Subject: A/31/19/PL

Please find my objection to application A/31/19/PL for 1 house on land between Ashurst and Badgers , Ham Manor Way.

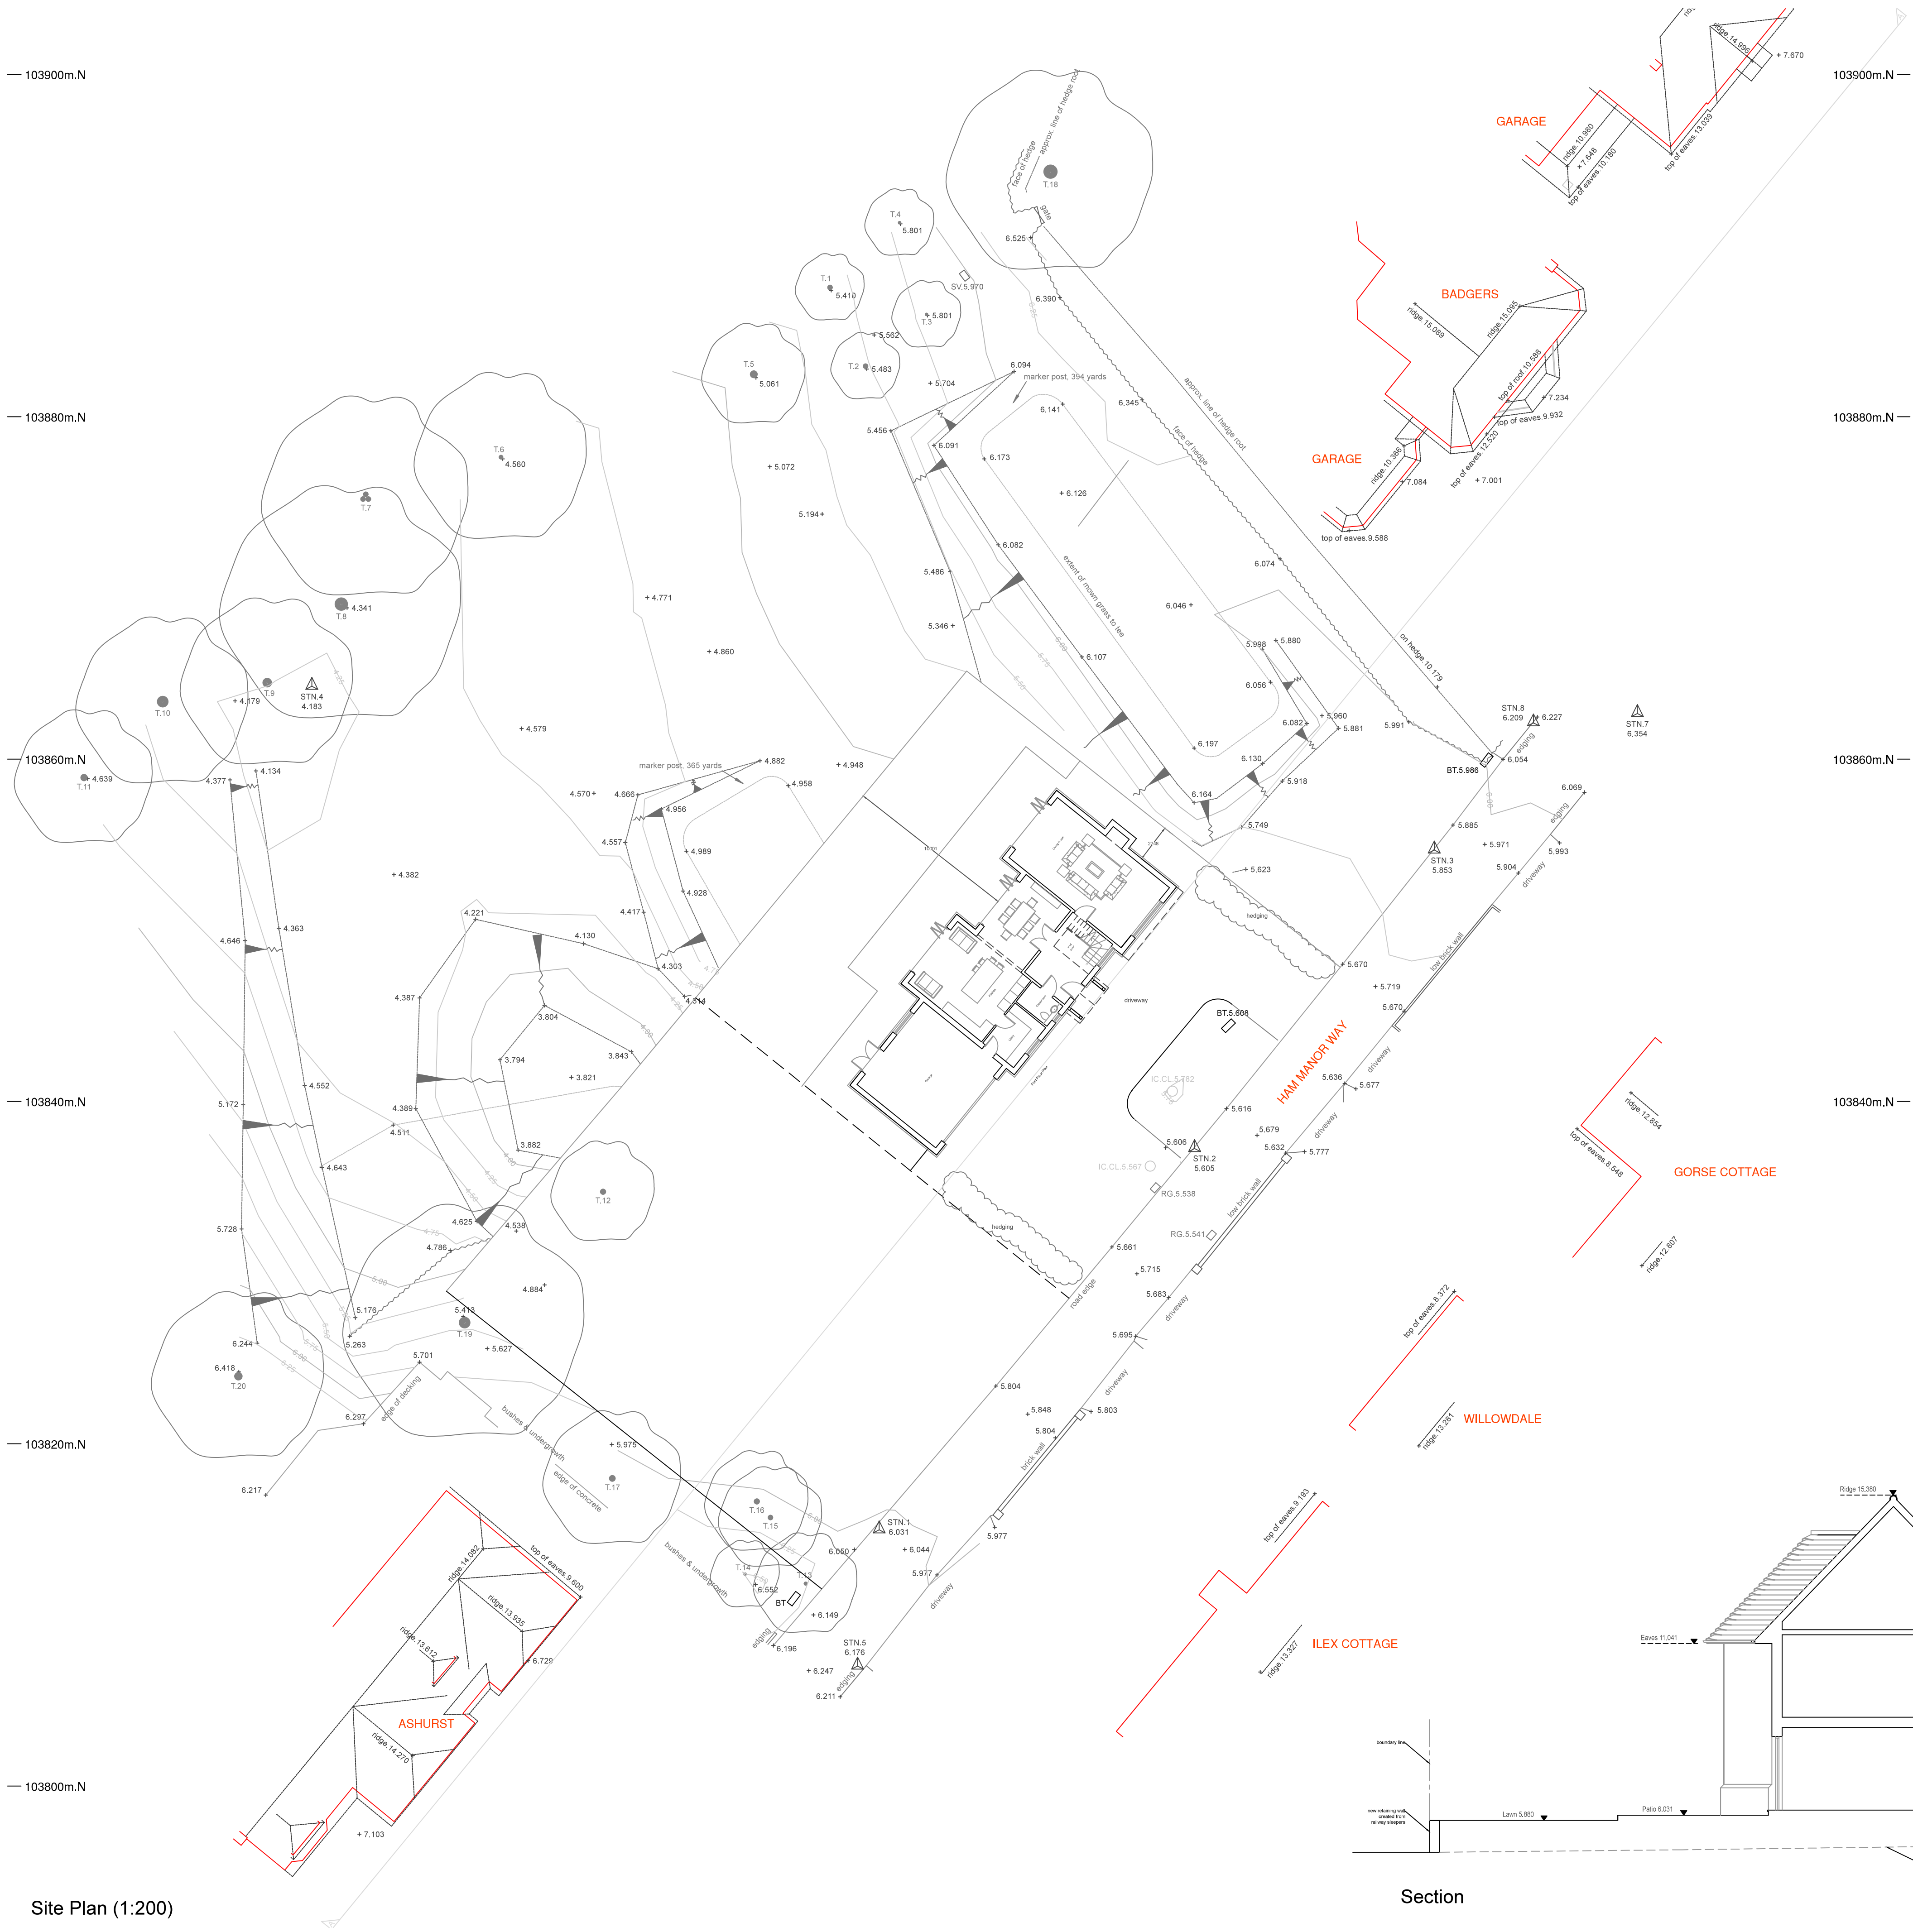
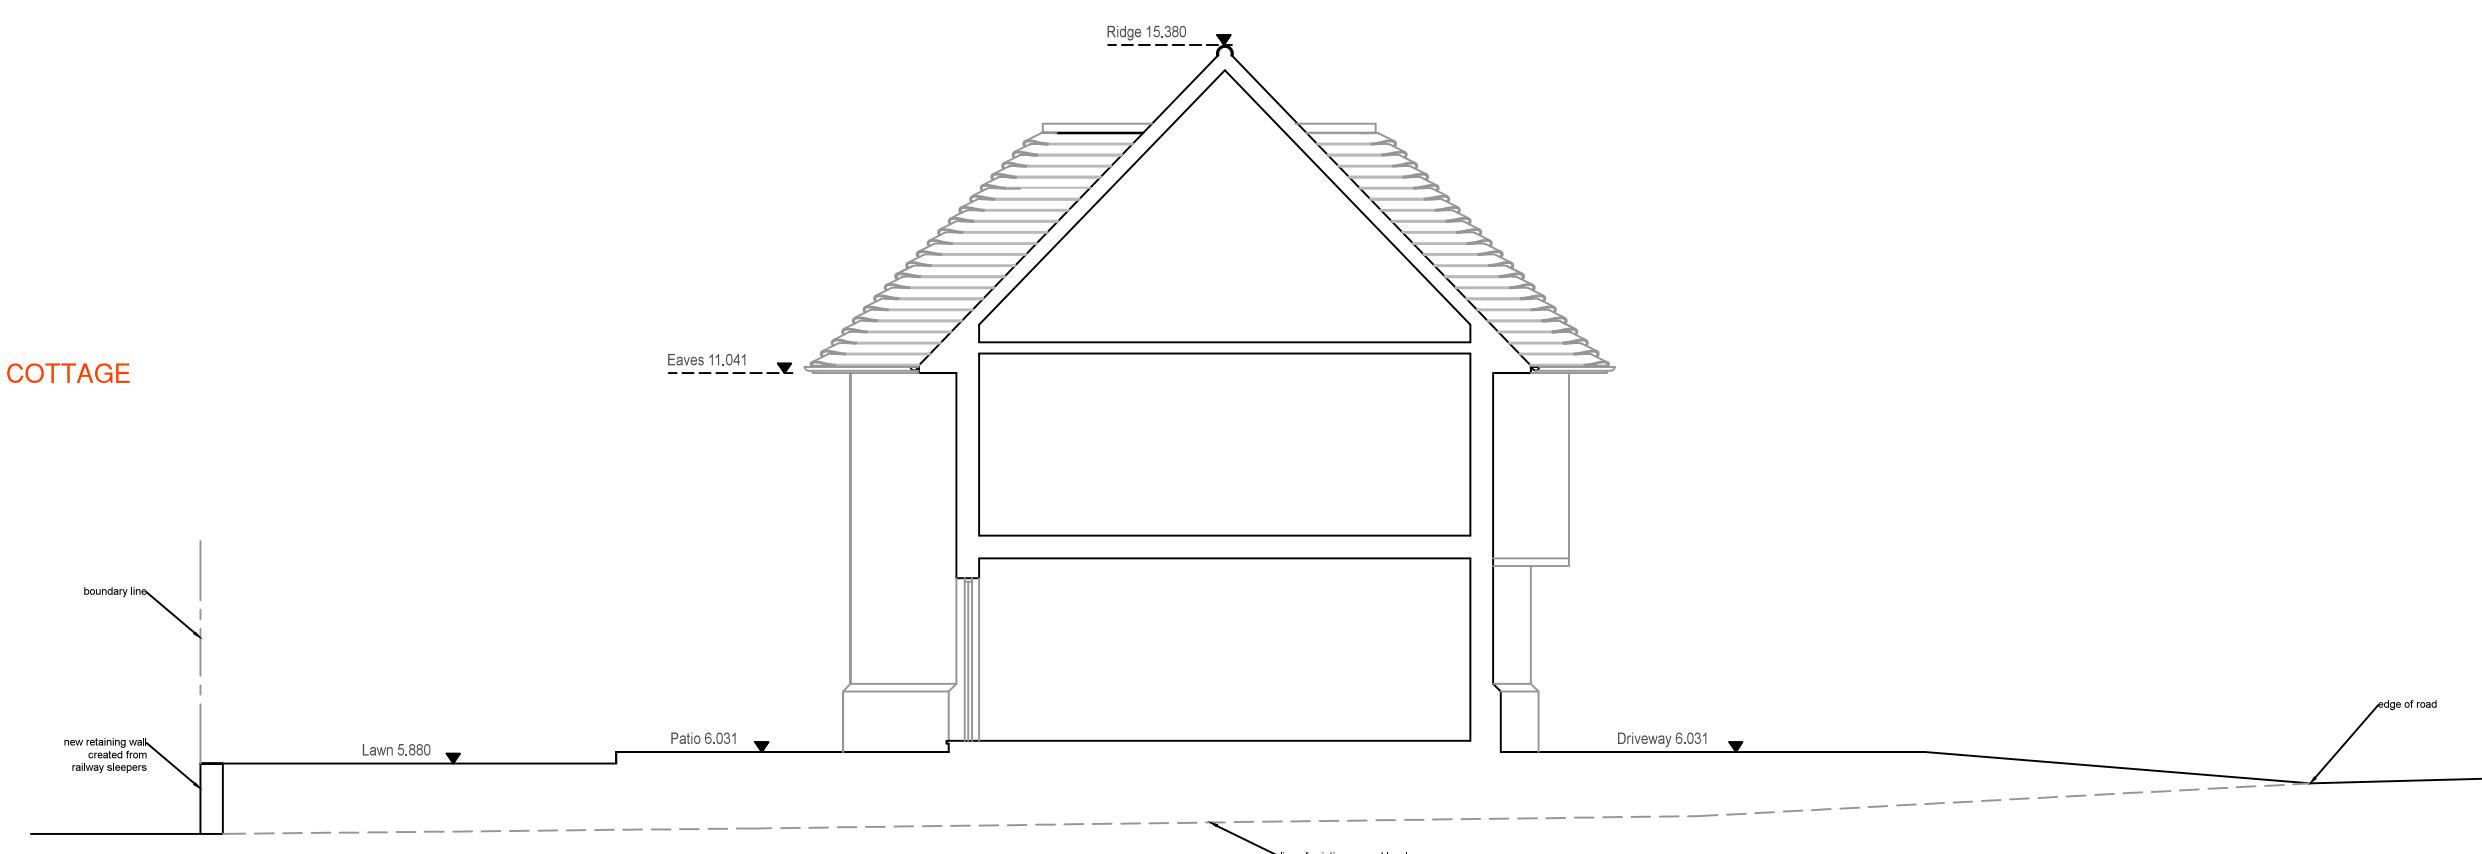
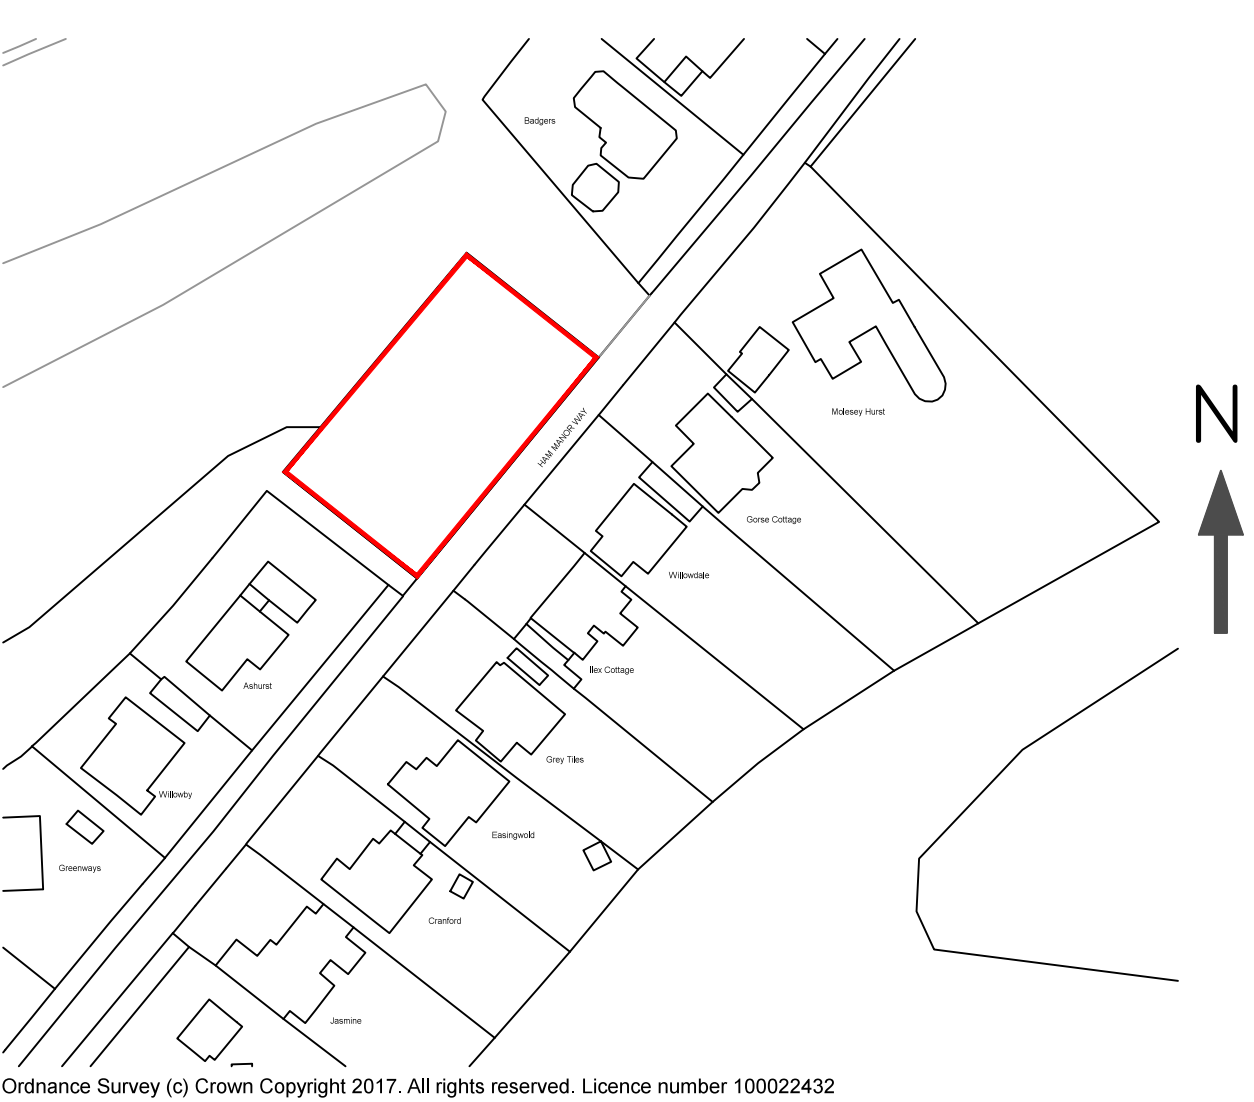
This property has been plonked in the centre of the ninth green space and sits forward of existing building lines in order to provide for an adequate rear garden. No consideration has been given by the applicants to previous reasons for refusal , especially in light of the recent appeal on A/176/17/PL and the Inspectors specific comments regarding the development of the CLP plots.

The applicant is proposing on the application that only one large house will be built on plot 9 with plot 8 designated as garden.
